Chatswood Chase Shopping Centre Table of Response to Submissions

The table below summarises the responds to issues raised as part of the exhibition of the EAR. The table should be read in conjunction with correspondence from WCC dated 8 August 2007 provided in Appendix A.

**PROPOSED
LEVEL 2 PLAN**

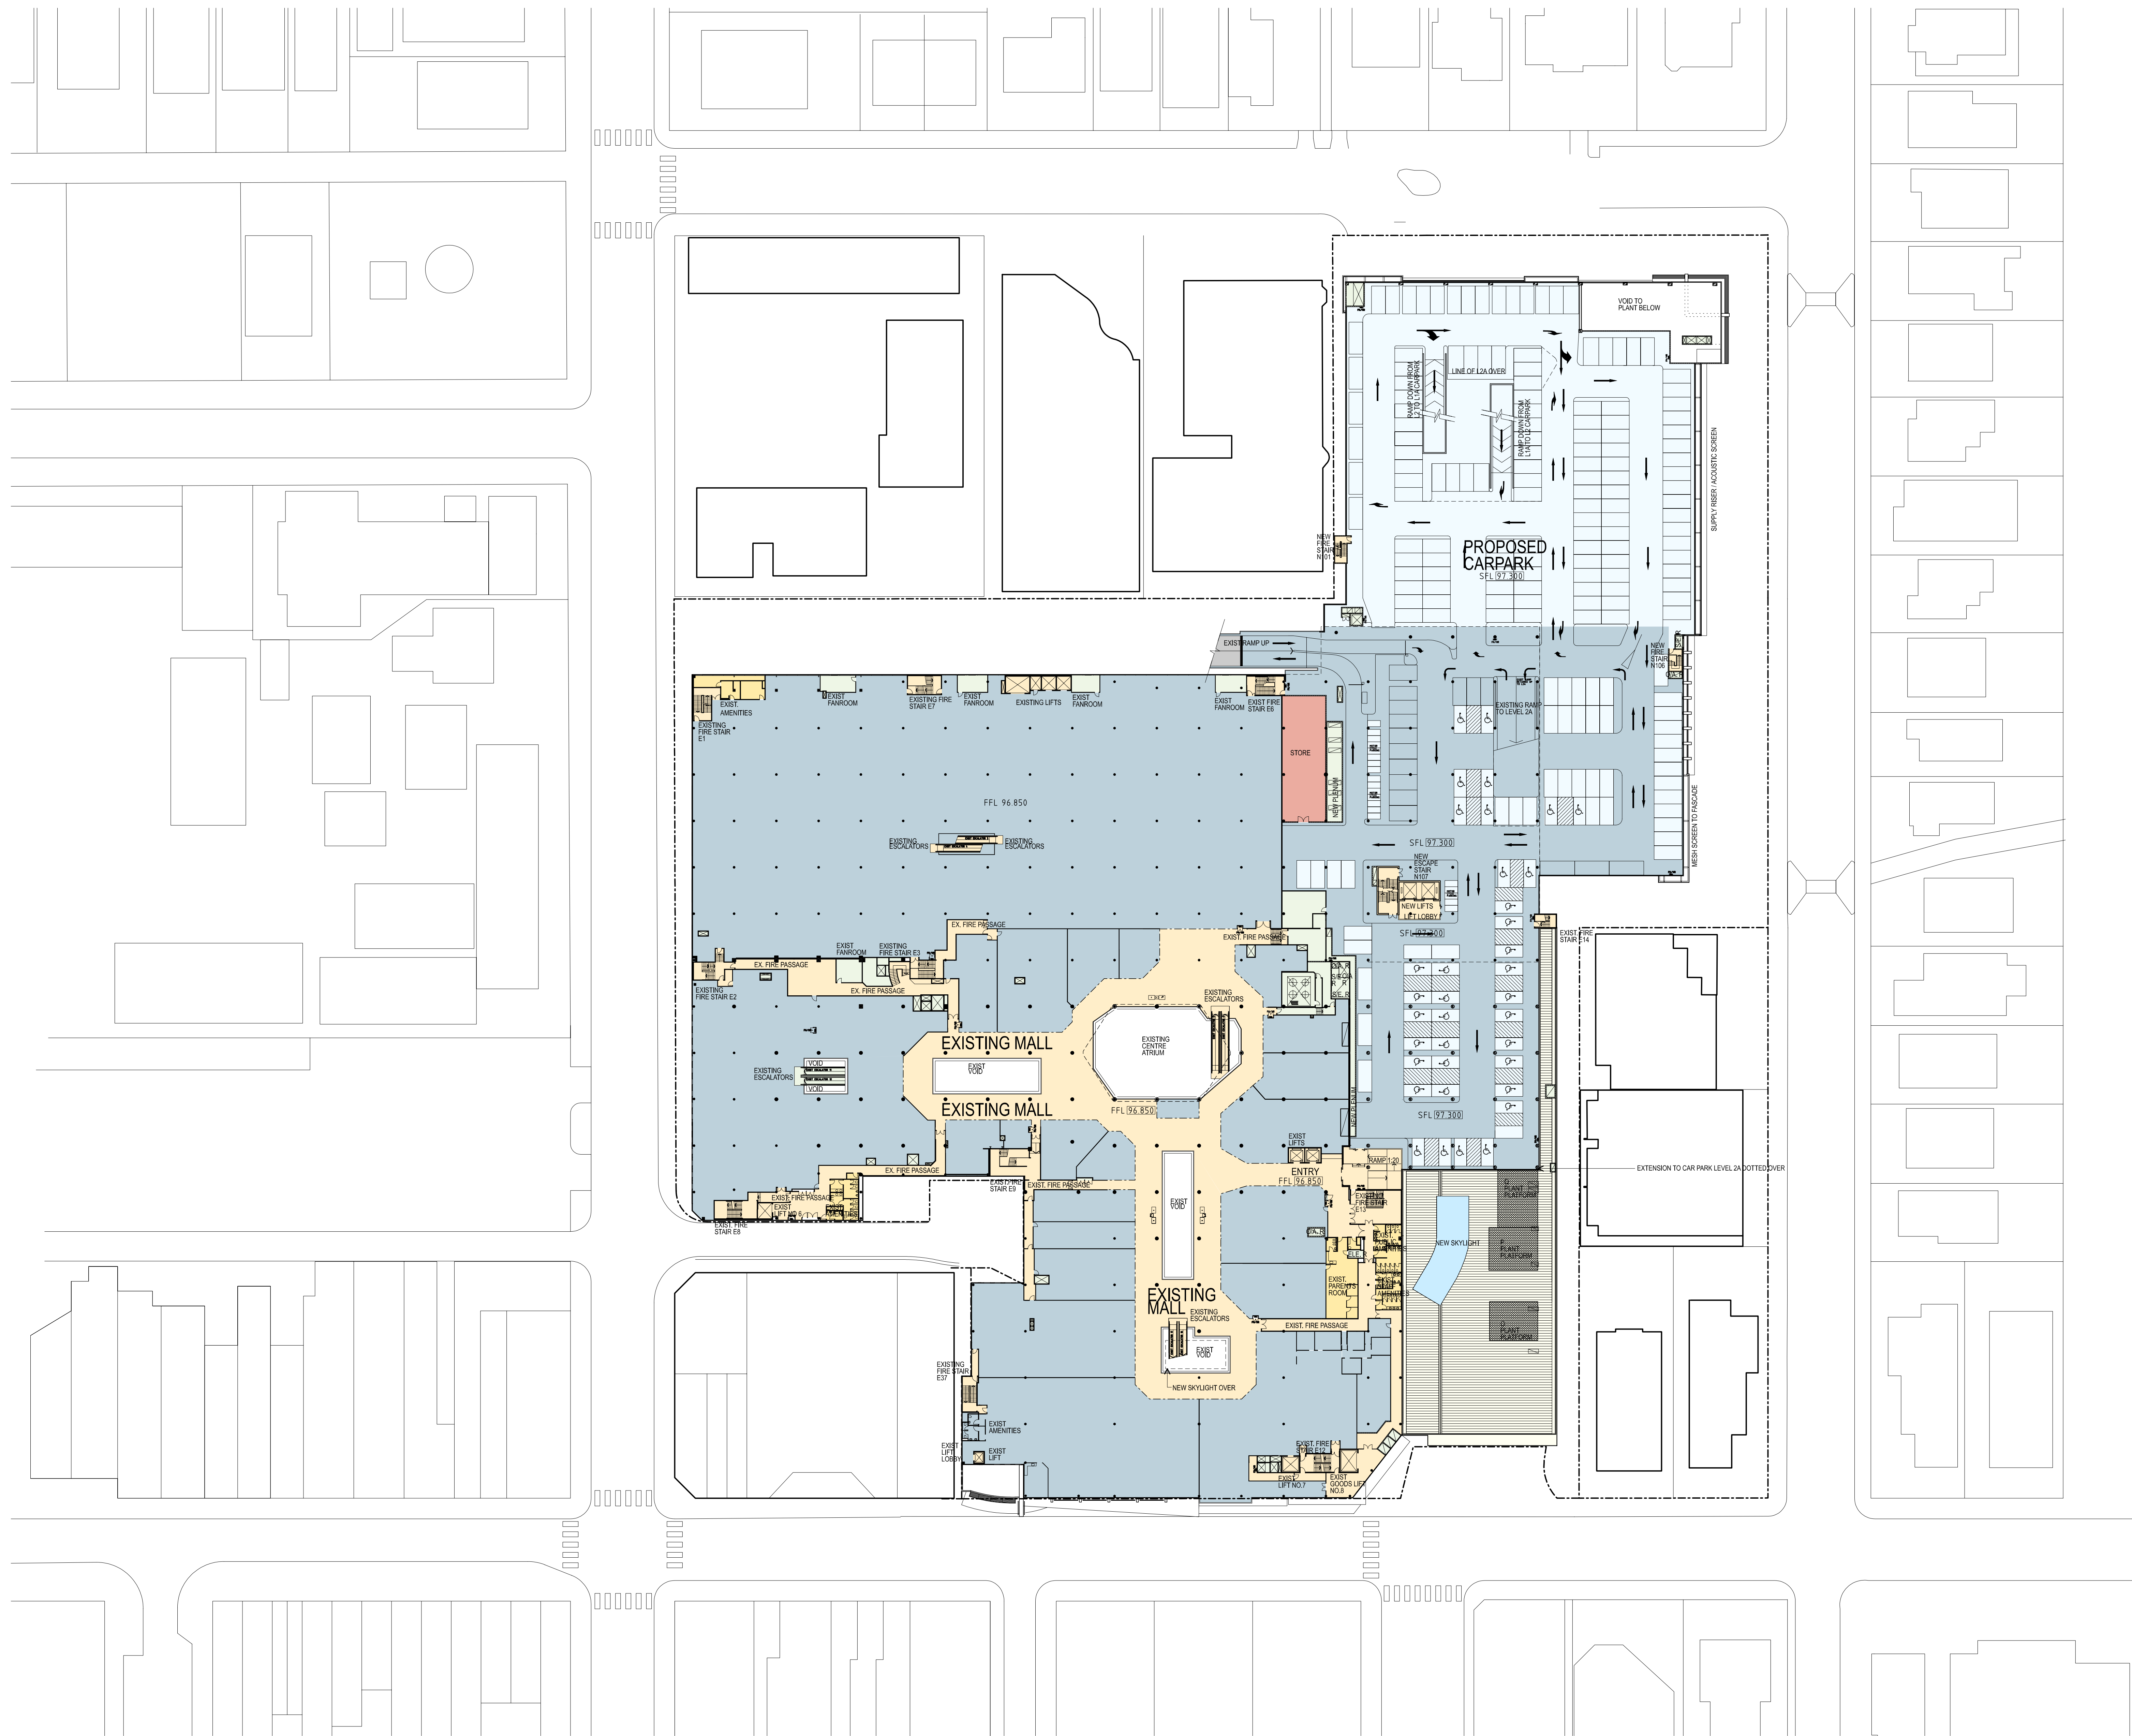
26	Further given the extent of demolition, redesign and reconstruction of the car park levels and the loading dock from Malvern Avenue, the design needs to consider achieving the head room requirements (2.5 metres) for car spaces for people with disabilities.	New spaces are located on Level 2 and are proposed to have a vertical clearance of 2.5m above them. Because of the need to match existing floor levels it will not be possible to provide such headroom elsewhere in the car park.
27	The maneuvering of delivery vehicles is not to be compromised by columns located in the manoeuvring area. Unobstructed head room in the truck loading areas shall be a minimum of 4 metres.	Headroom in the new Coles loading area will be a minimum of 4m.
